# **KIRKLEES METROPOLITAN COUNCIL INVESTMENT & REGENERATION SERVICE**

### **DELEGATED DECISION TO DETERMINE PLANNING APPLICATIONS**

| Site Address:         | 43, Arthur Street, Golcar, Huddersfield, HD7 4DF |
| Description:          | Erection of two front dormers                    |

Proposed Plans and Elevations

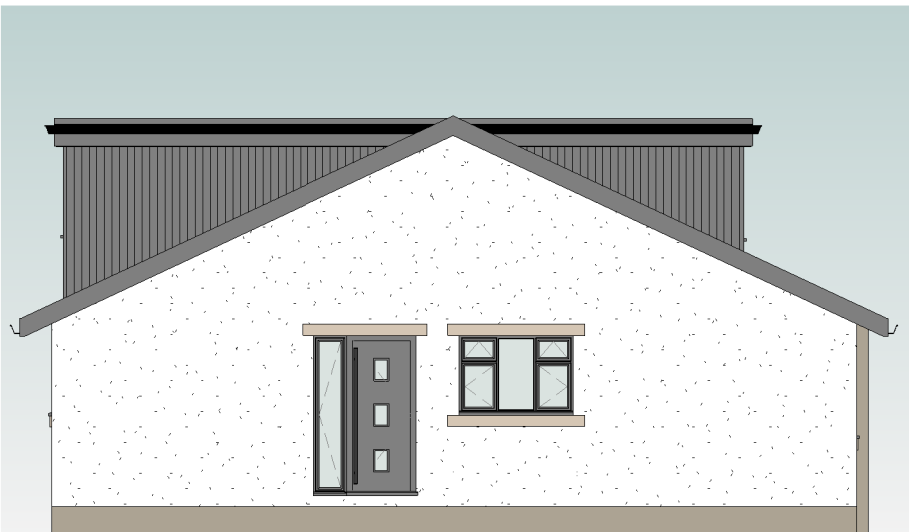
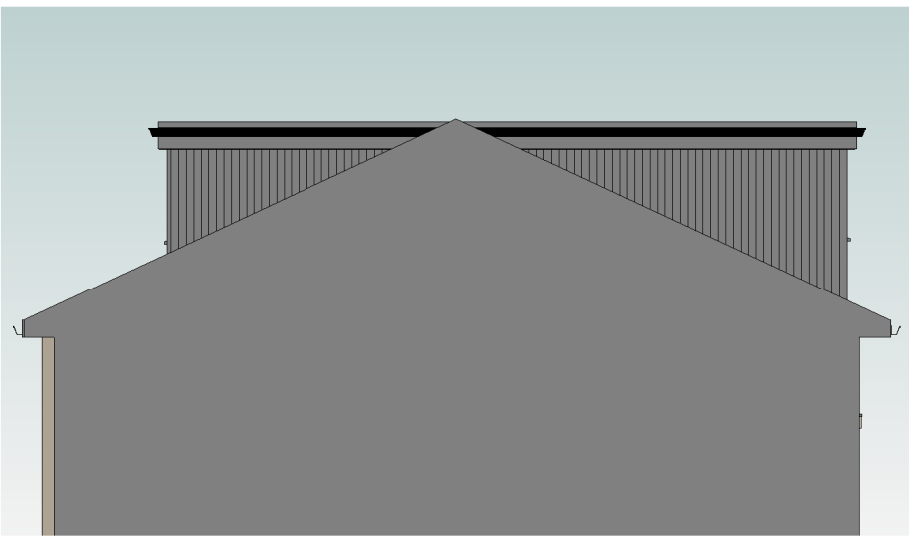
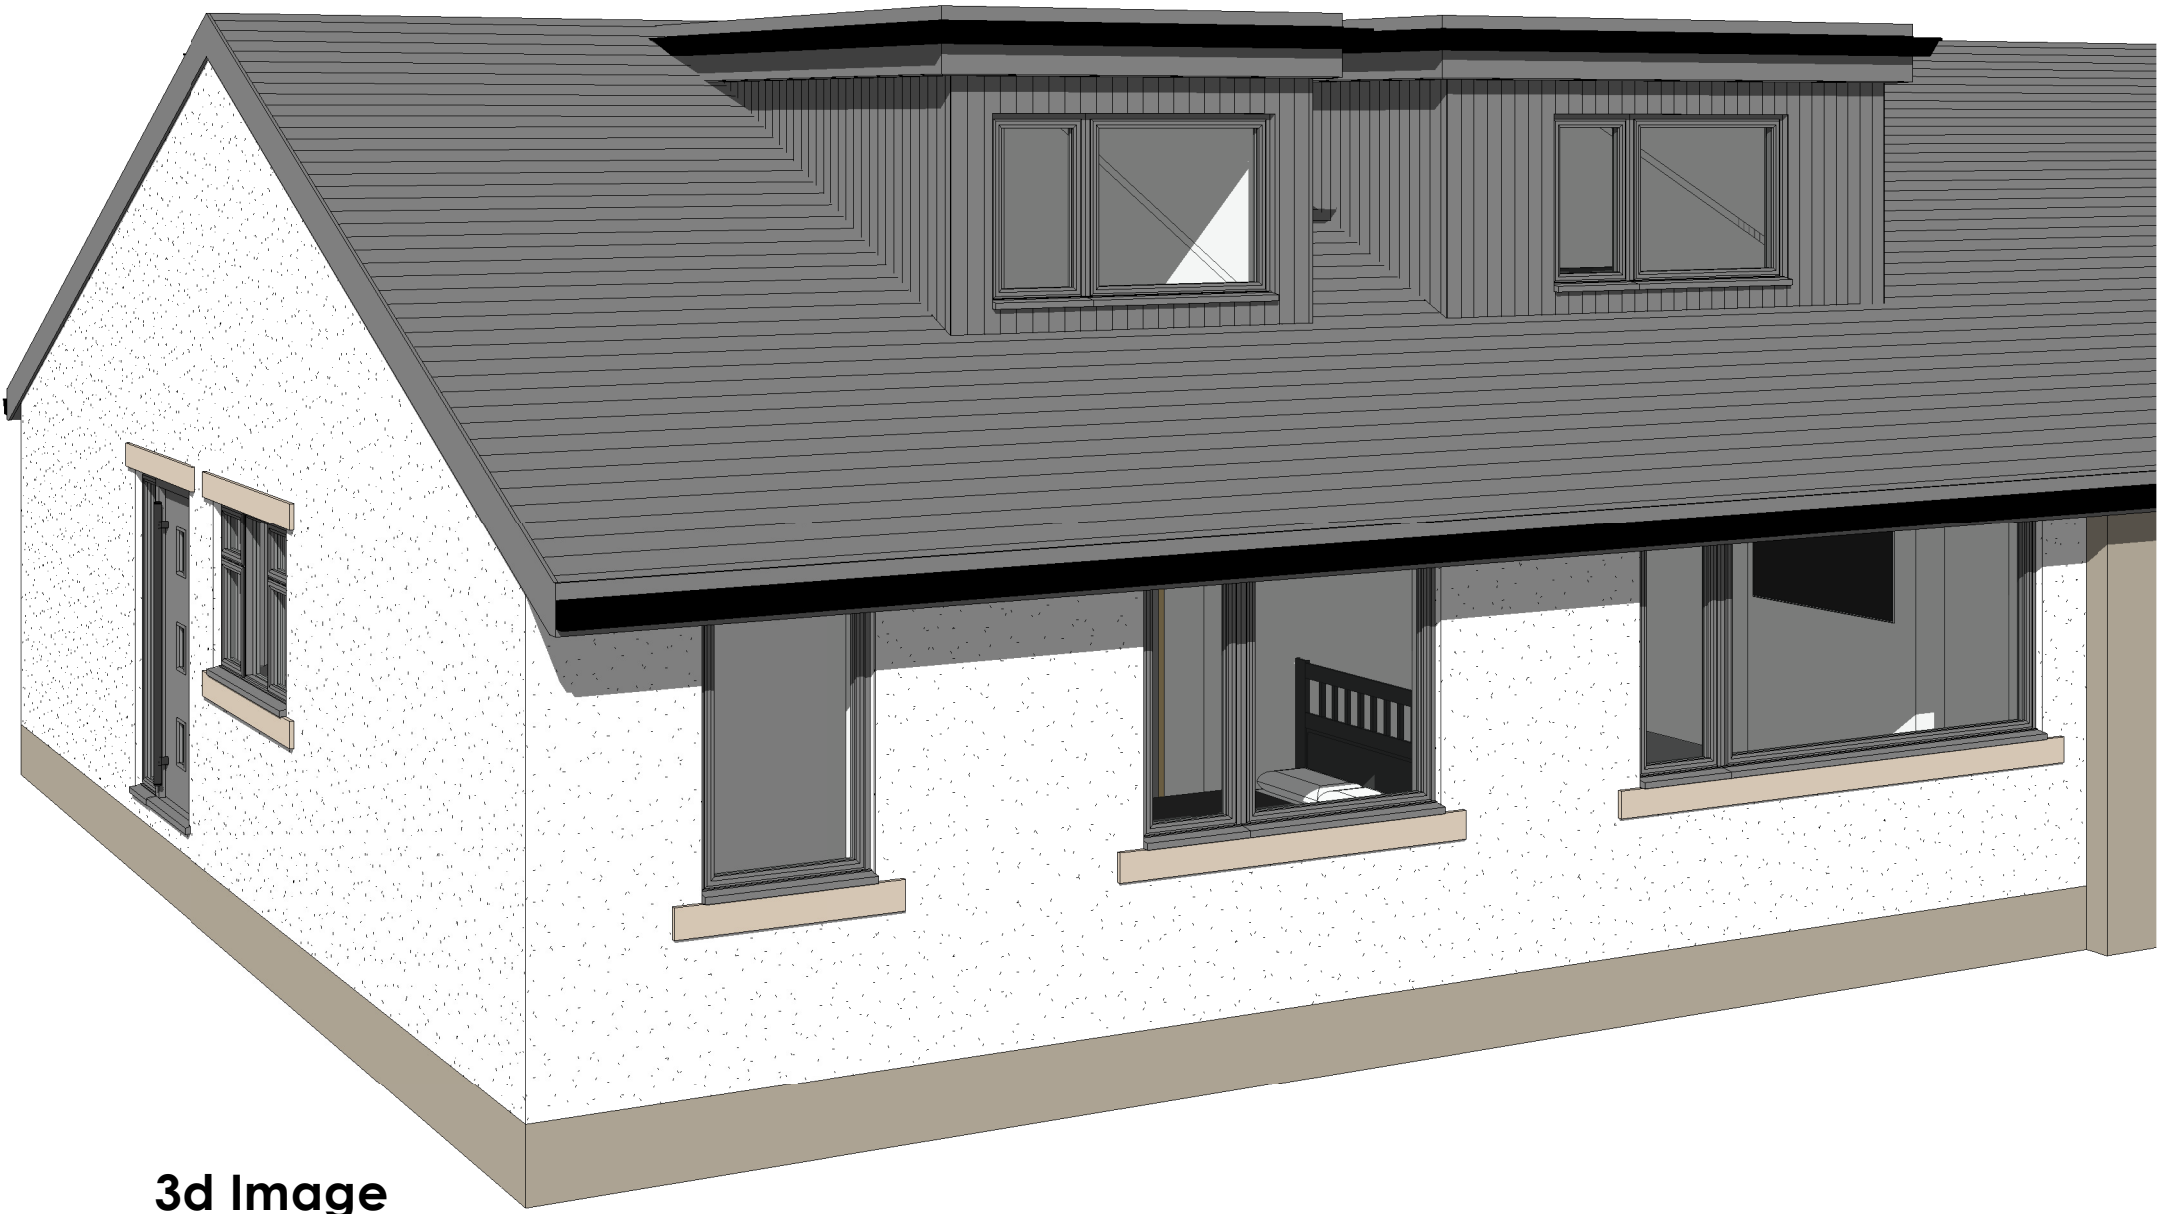
| <b>Dormer extensions should:</b>                                                                         | <b><u>Yes - COMPLY</u></b>                                                                                                                                                              | <b><u>No - JUSTIFY</u></b>                                  |
|----------------------------------------------------------------------------------------------------------|-----------------------------------------------------------------------------------------------------------------------------------------------------------------------------------------|-------------------------------------------------------------|
| not dominate the roof or project above the ridge of the house                                            | Yes set within both sides of the exiting roof slope with a gap between each dormer clearly defining two separate dormer extensions                                                      |                                                             |
| be set below the ridgeline of the existing roof and within the roof plane                                |                                                                                                                                                                                         | No – in line with existing roof ridge – same as rear dormer |

|                                                | <b>Relevant key design principle (KDP) of the SPD, Policy in the Kirklees Local Plan and the NPPF</b>                                                                  | <b>Further comments</b>                                                                                                                                                                                         | <b>✓ /<br/>X /<br/>N/A</b> |
|------------------------------------------------|------------------------------------------------------------------------------------------------------------------------------------------------------------------------|-----------------------------------------------------------------------------------------------------------------------------------------------------------------------------------------------------------------|----------------------------|
| Height, scale and massing                      | <ul style="list-style-type: none"> <li>• KDP 1 and 2 of the SPD</li> <li>• Policy LP24 Design (a), (c) and (d) of the KLP</li> <li>• Chapter 14 of the NPPF</li> </ul> | Set up from the gutter line and set in from the sides of the property with an obvious gap between the two dormers                                                                                               | ✓                          |
| Facing materials and detailing                 | <ul style="list-style-type: none"> <li>• KDP 9 of the SPD</li> <li>• Policy LP24 Design (d) (iii) of the KLP</li> <li>• Chapter 14 of the NPPF</li> </ul>              | Cladding to match the rear dormer and existing roof tiles – this can be conditioned to match the colour finish of the existing roof                                                                             | ✓                          |

The inclusion of flat roof dormers to front is not a typical character to this part of the street, however in closer proximity to the south and east of the site such additions are more commonplace, of a larger scale and of a less in keeping design.

In this case weight is afforded this varied character of the locality and on balance given the scale of the dormers proposed it is considered their design would not have such an impact upon the character of the street that refusal could be substantiated in this case. It is considered that on the basis of a dark grey colour finish the dormers would read as in keeping with the character of the house types in the locality given the wider context against which they would be viewed with dwellings featuring flat roof additions being within the sider street scene.

3. The hereby approved dormers shall be either vertically slate hung with slates that in all respects match those used on the existing roof or be clad with a colour finish which is a colour to match the existing roof. The materials of construction and colour finish shall be completed before the development is brought into use and shall thereafter be retained.
